September 23, 1999

RE: 46 Codman Street (128-A-008 & 129-H-016) - R-3

I am in receipt of your permit to construct a new single family dwelling. This permit is being denied. At present, this lot is considered to part of another lot at 43 Chenery Street. It appears that this lot containing a garage, which is considered to be an accessory use to 43 Chenery Street, has illegally been subdivided and thereby created an illegal lot. It is illegal under the Zoning Ordinance to create a nonconforming lot. This lot is nonconforming because it contains a garage, which is not a principal use in this zone. The garage also does not meet the required rear setbacks for the R-3 zone. Your site plan shows the garage to be 13.7 feet from the rear lot line. The R-3 zone requires a 25 foot rear setback.

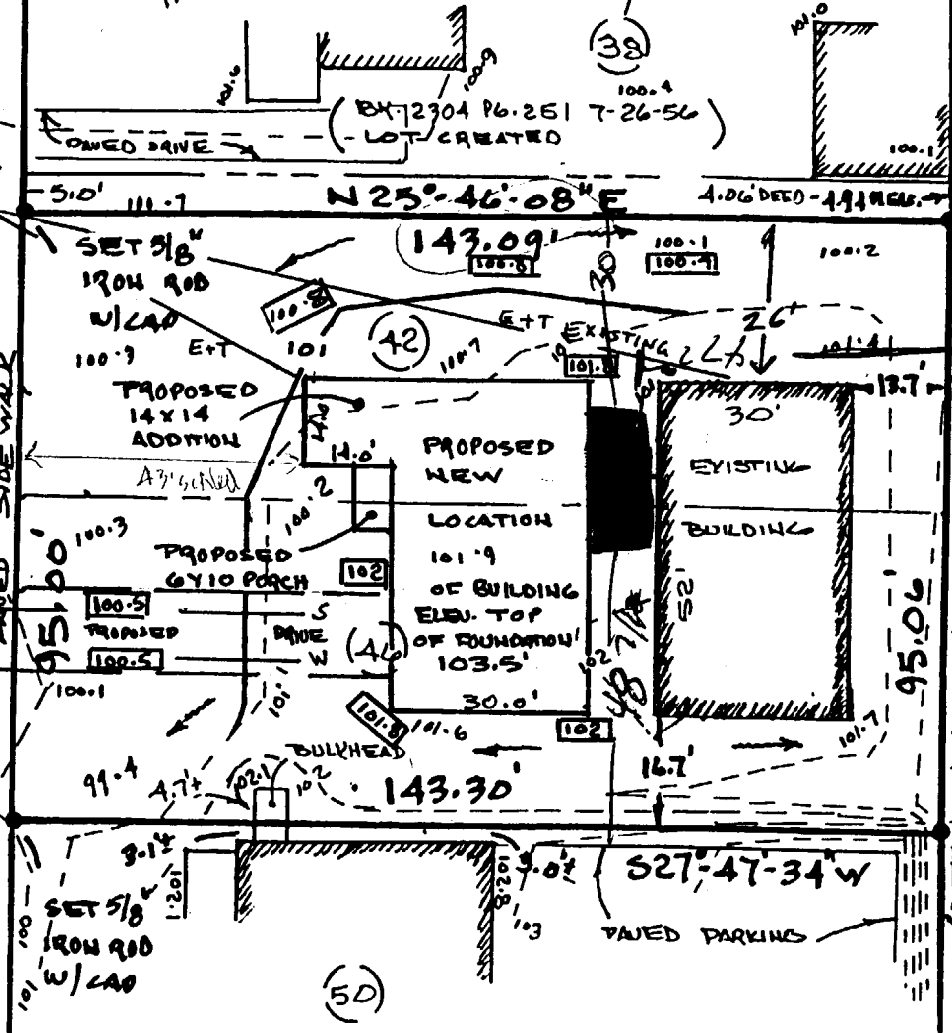
Before this office can entertain allowing a new single family dwelling, it will be necessary to review how the original lot was split into two lots. It will also be necessary to move the current garage to a 25 foot rear setback.
